2022/1086

Erection of illuminated standalone totem sign adjacent the site entrance

Peel Centre, Peel Centre Retail Park, Harborough Hill Road, Barnsley, S71 1BQ

Drawing ref: 210249 SK_101

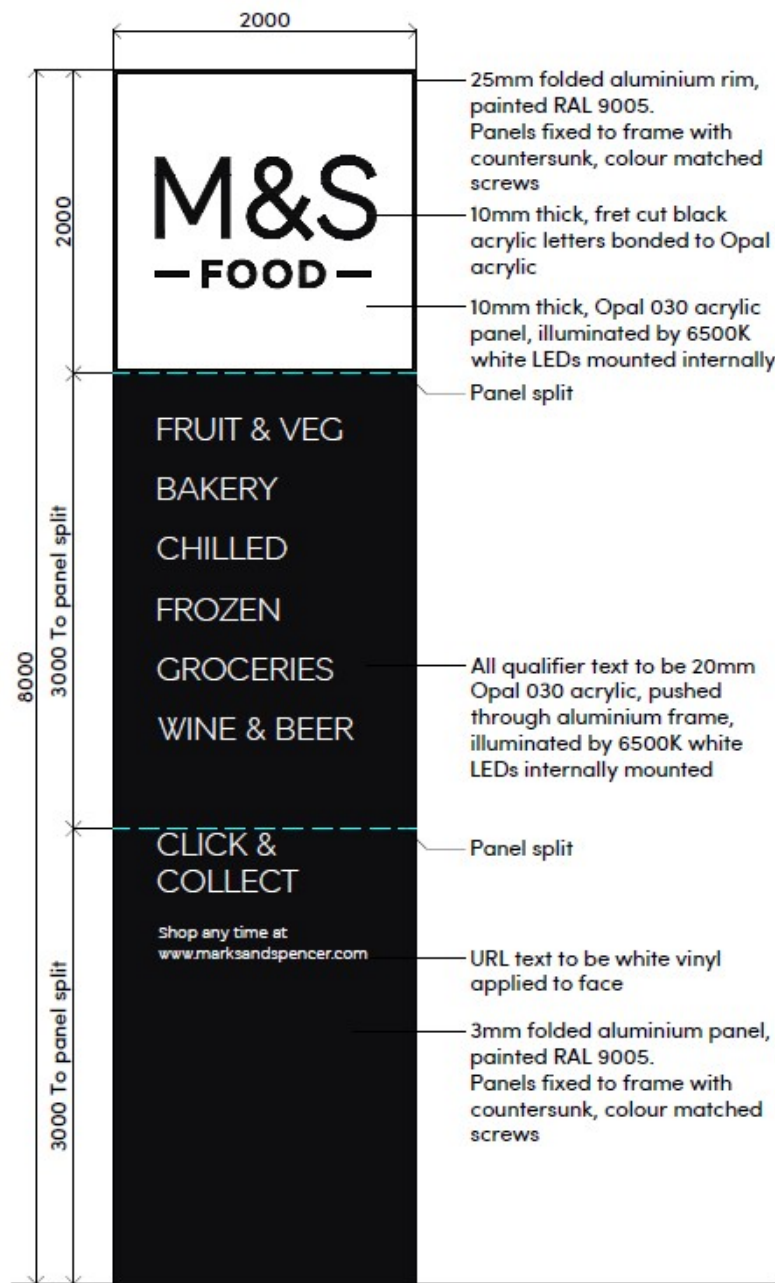
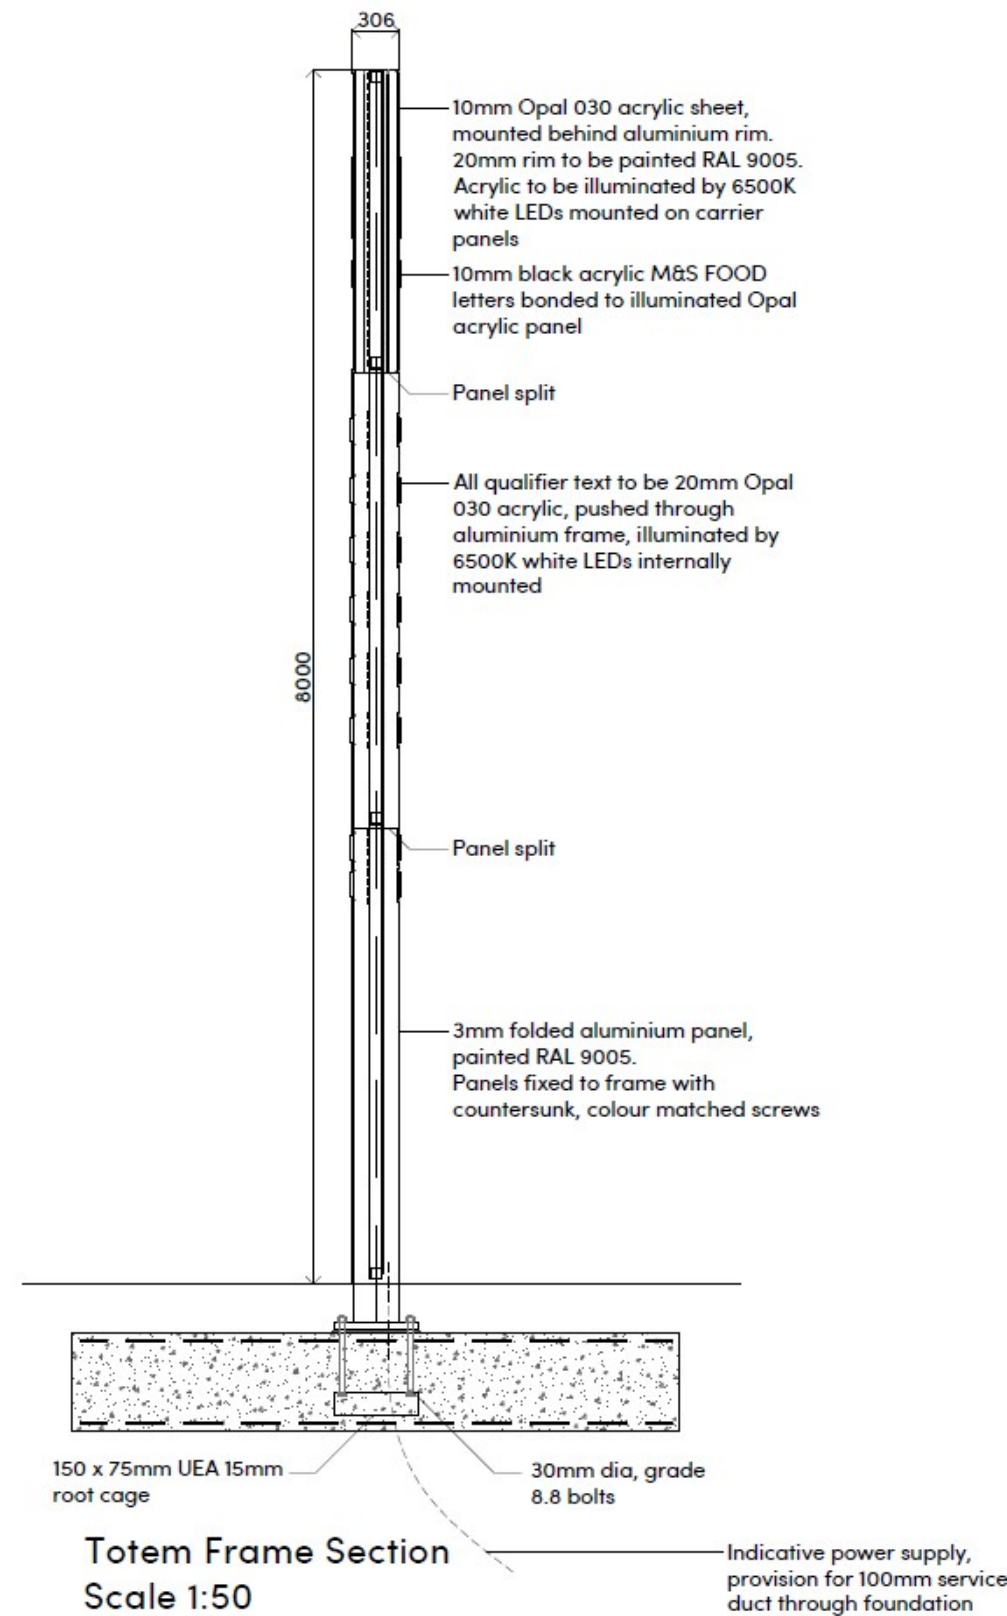
Permission is sought to display a new totem sign measuring 8 metres high, 2 metres wide and 0.306 metres deep and illuminated to 350cd/m²

The proposed sign is sited well clear of the highway and visibility splays. The proposed luminance is within the recommended maximum levels. It is concluded that the sign would not be prejudicial to public highway safety.

The sign is proposed to be sited next to an existing (smaller) Starbucks totem sign at the entrance to the retail park. The existing Starbucks sign is sited on the opposite side of the Dryden Road entrance from a monolith sign and far enough away from it that it doesn't result in an unacceptable proliferation and clutter. However the proposed sign would be sited next to the Starbucks sign and would be significantly wider and taller than that existing sign.

It is concluded that the proposed sign would give rise to a cluttered and aggressively commercial appearance which would have an adverse impact on the appearance of the area.

It is concluded that the proposal is not acceptable in terms of its impact on visual amenity and is not in compliance with Local Plan Policies GD1 and D1 and the Advertisements SPD
